From: Martyn White **On Behalf Of** Conservation Officer
Sent: 19 October 2018 09:58
To: Planning.Responses
Subject: LU/223/18/PL & LU/224/18/L

LU/223/18/PL & LU/224/18/L

The application relates to the conversion of basement space and an area of the ground floor from Bookshop to 3 holiday lets. The applications affect a listed building which is visible on the street-scene within the town centre.

Proposed Floor Plans

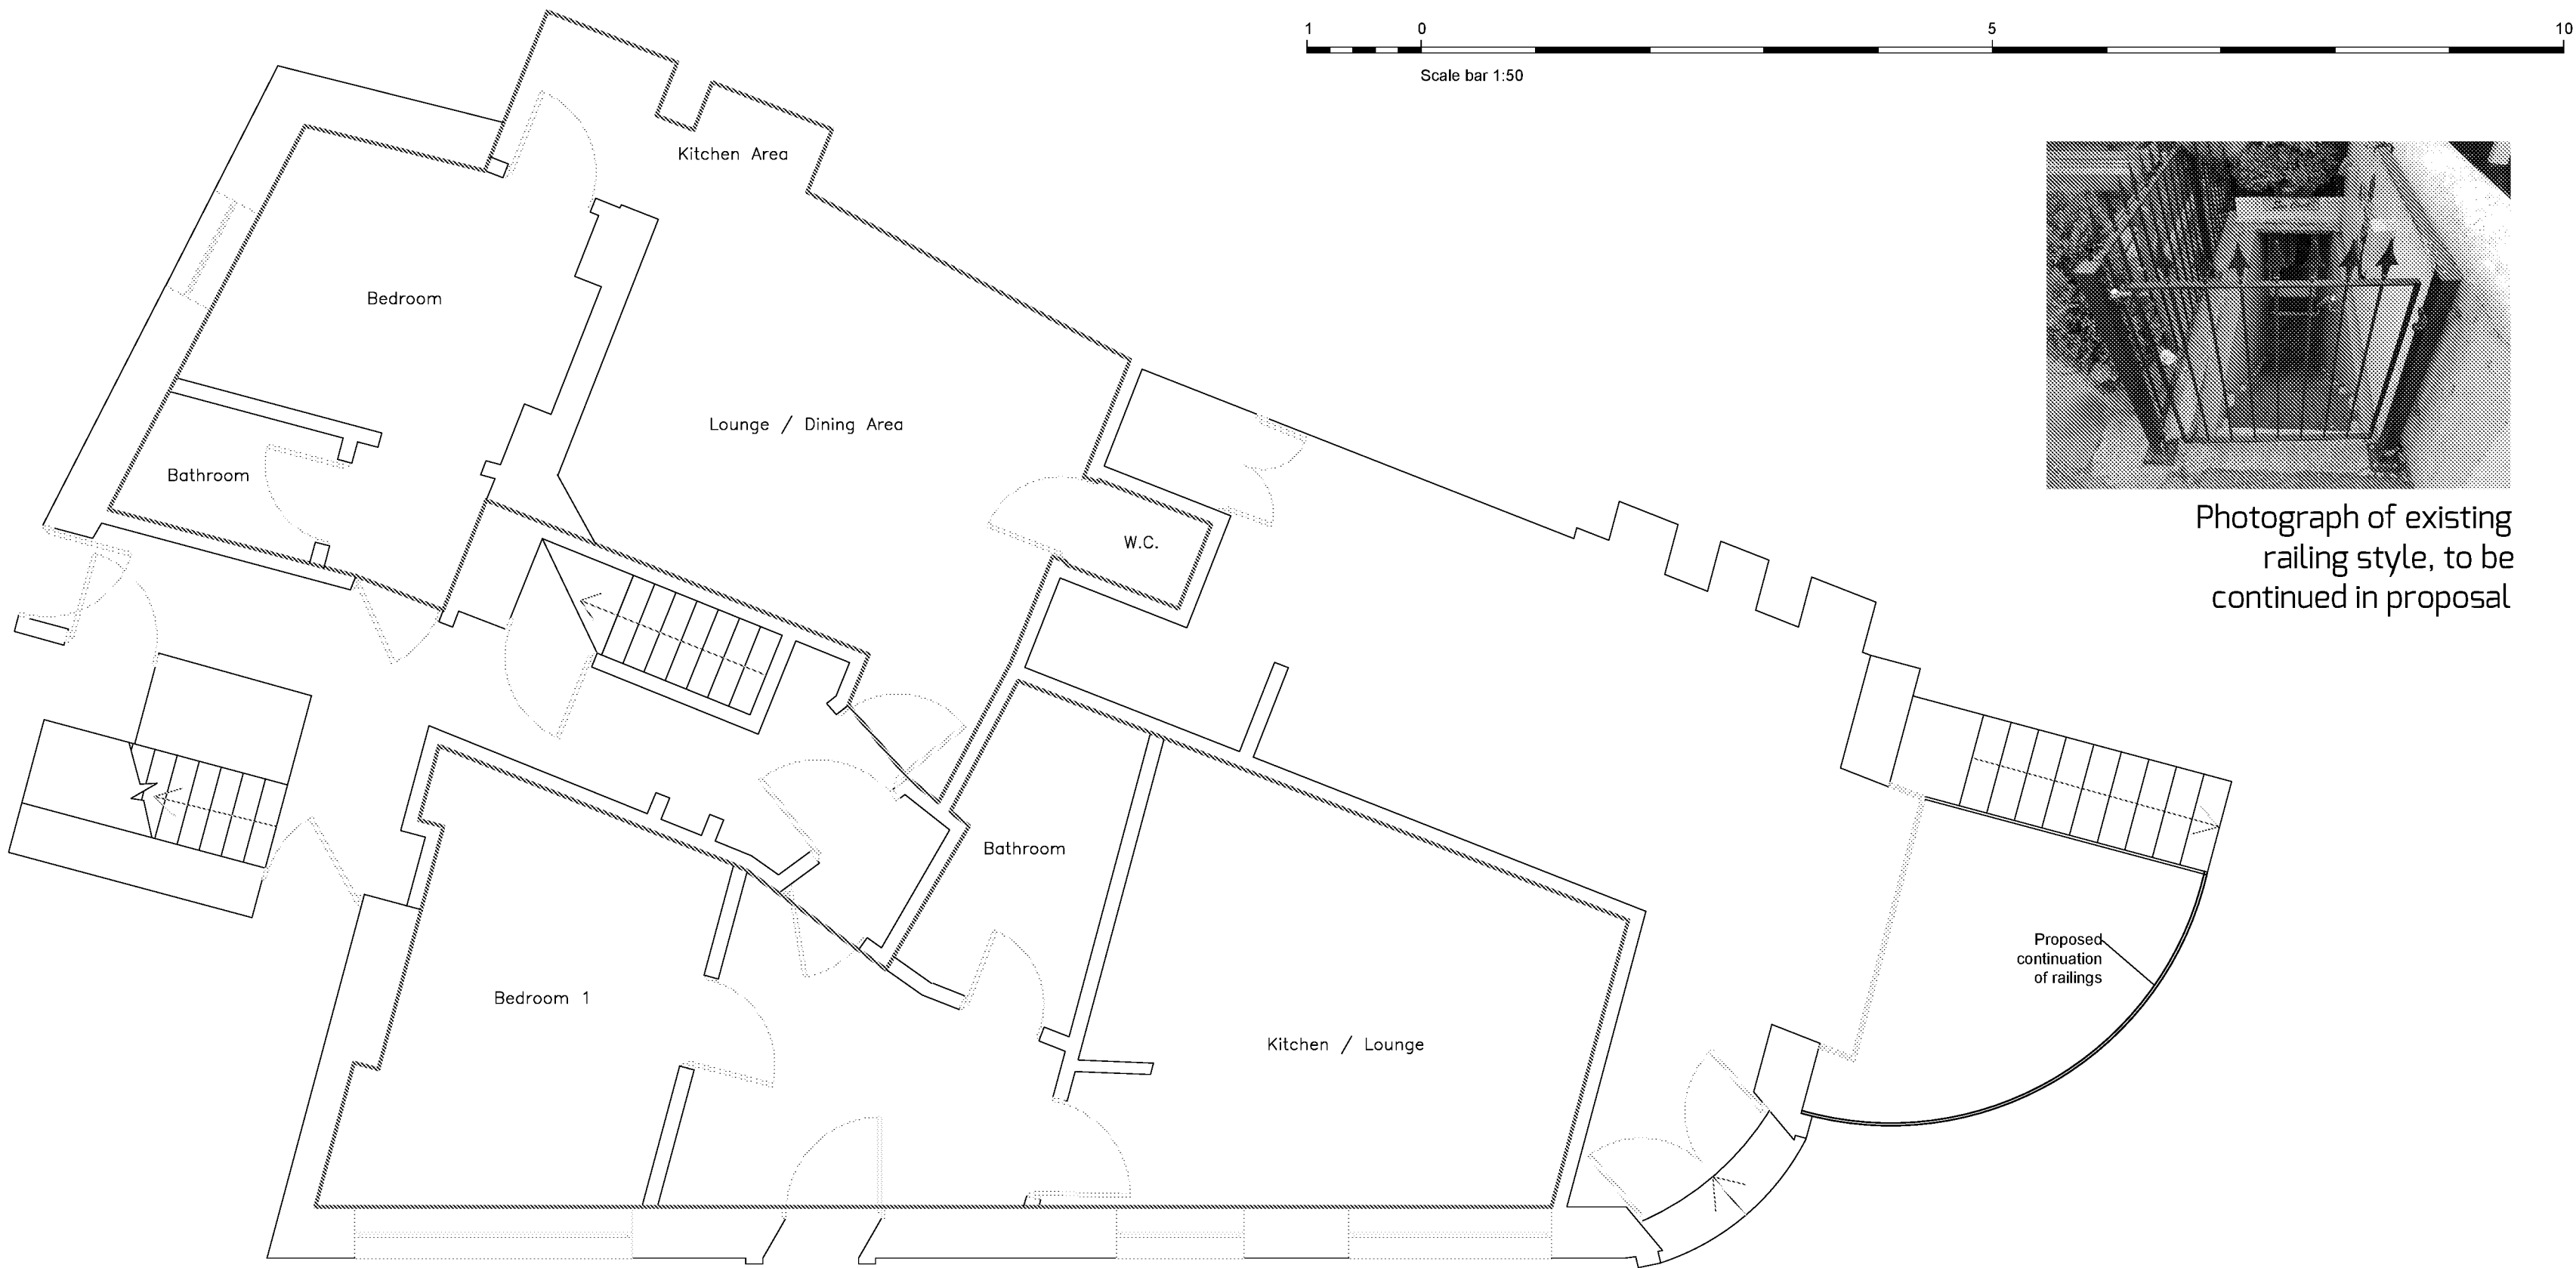
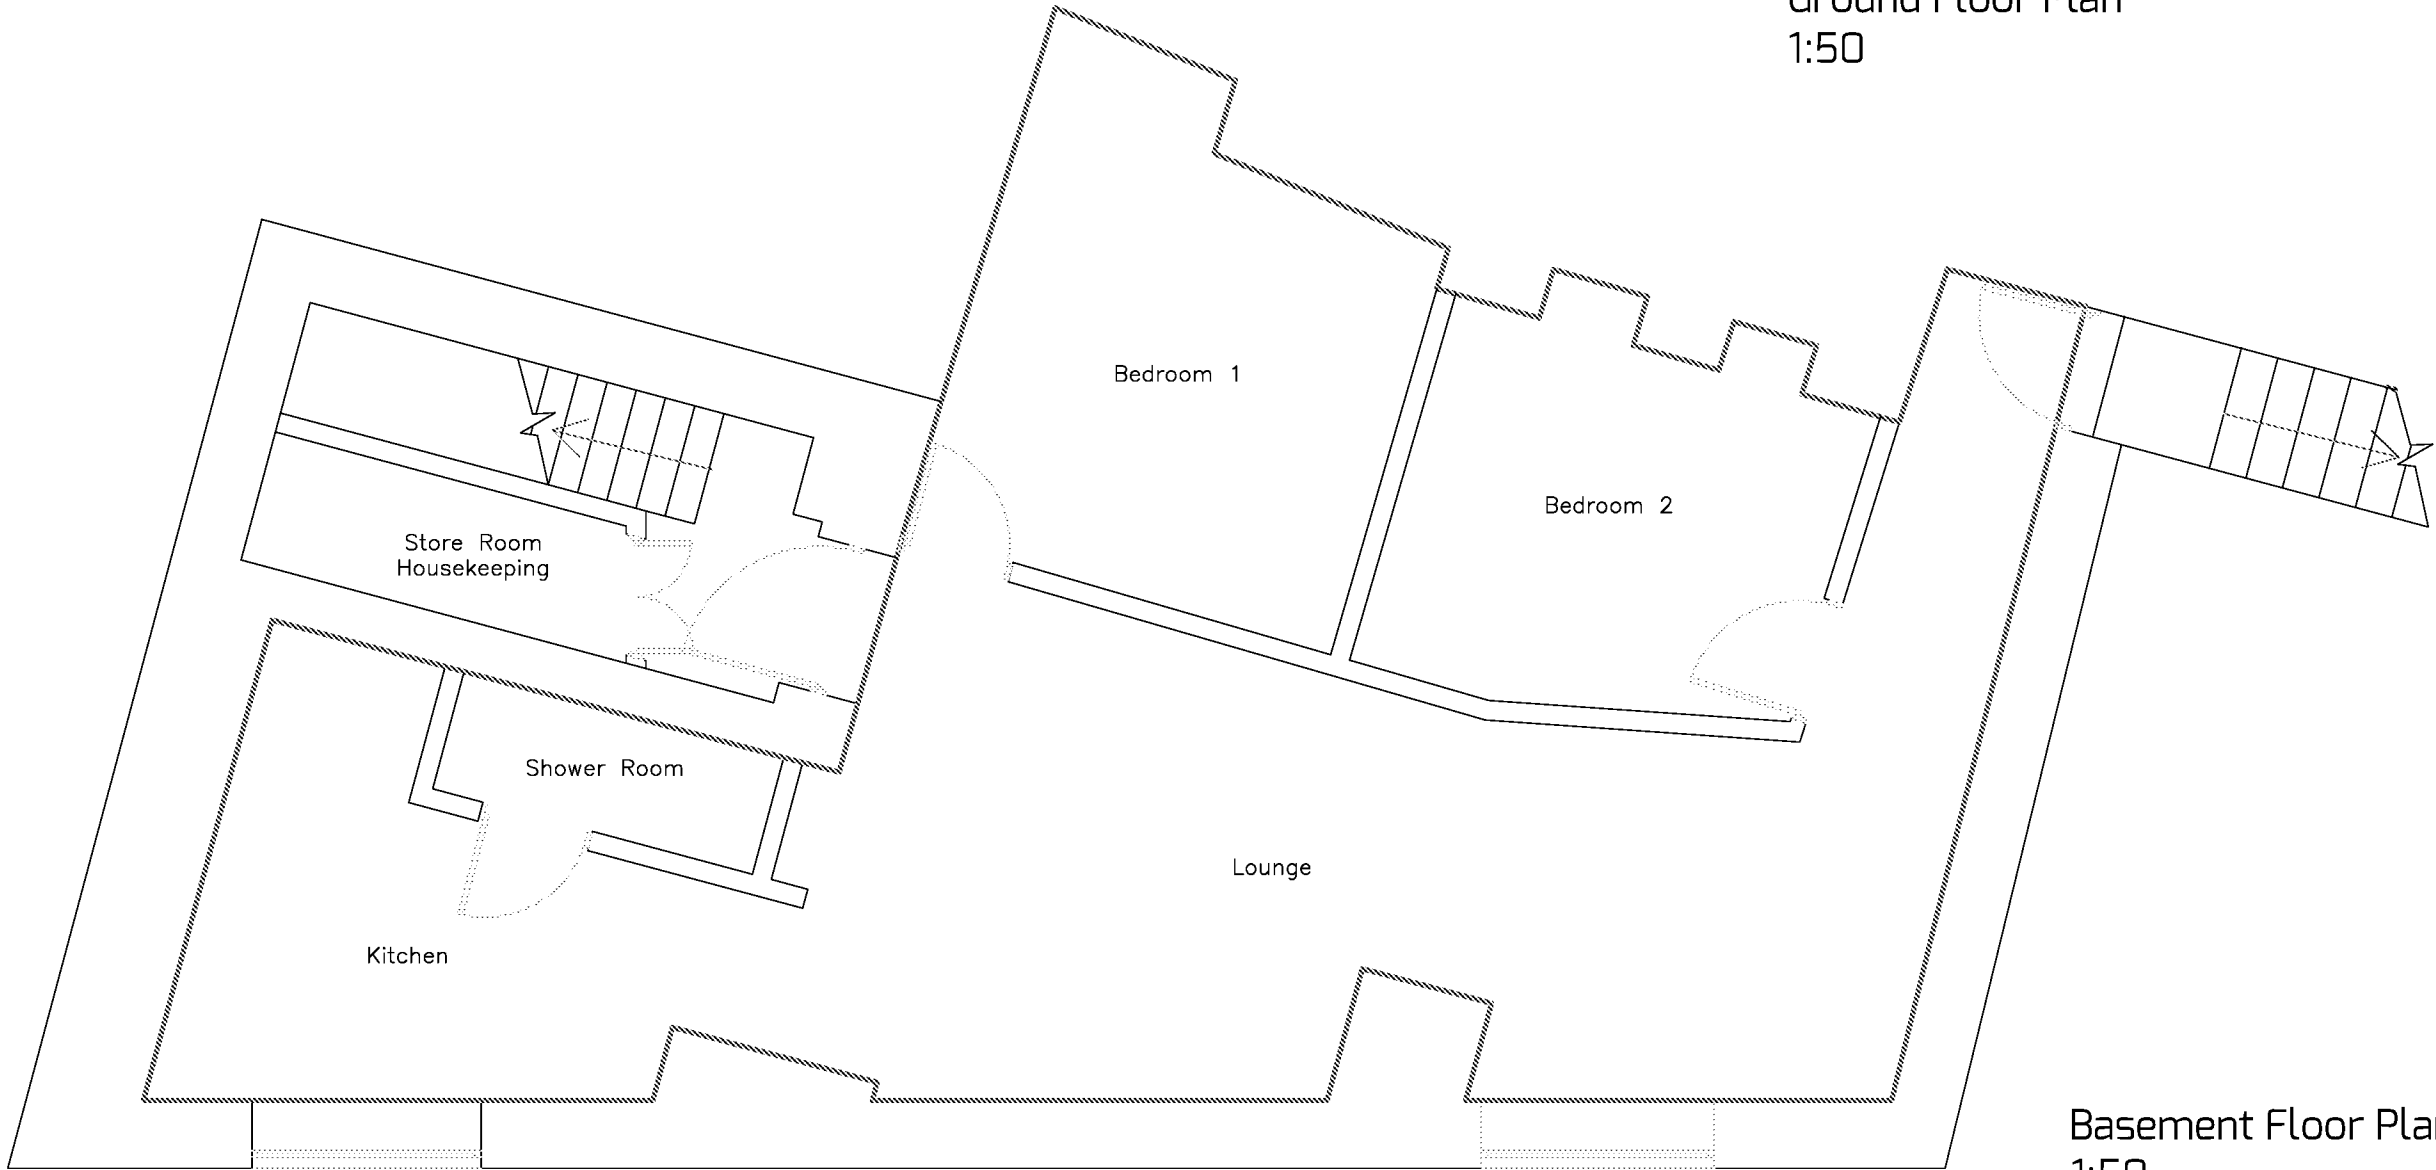
It is evident from looking at the existing and proposed floor plans that a significant amount of internal works have been undertaken in order to accommodate the new uses. As the works are retrospective, it is not possible to determine the scale of the impact i.e. in terms of the loss of historic fabric. It is considered that the proposed/implemented floor plan is acceptable as the majority of the floor plan is retained.

I note from the proposed floor plans that there is a proposal to install further railings to the front of the shop. Railings have been fitted into other parts of the conservation area where it has been proven that there were there historically. In addition, they should be of a design and materials to reflect the status of the property as a listed building, located within a conservation area. At the moment, it is not clear what the railings will look like, and a full commentary cannot be provided.
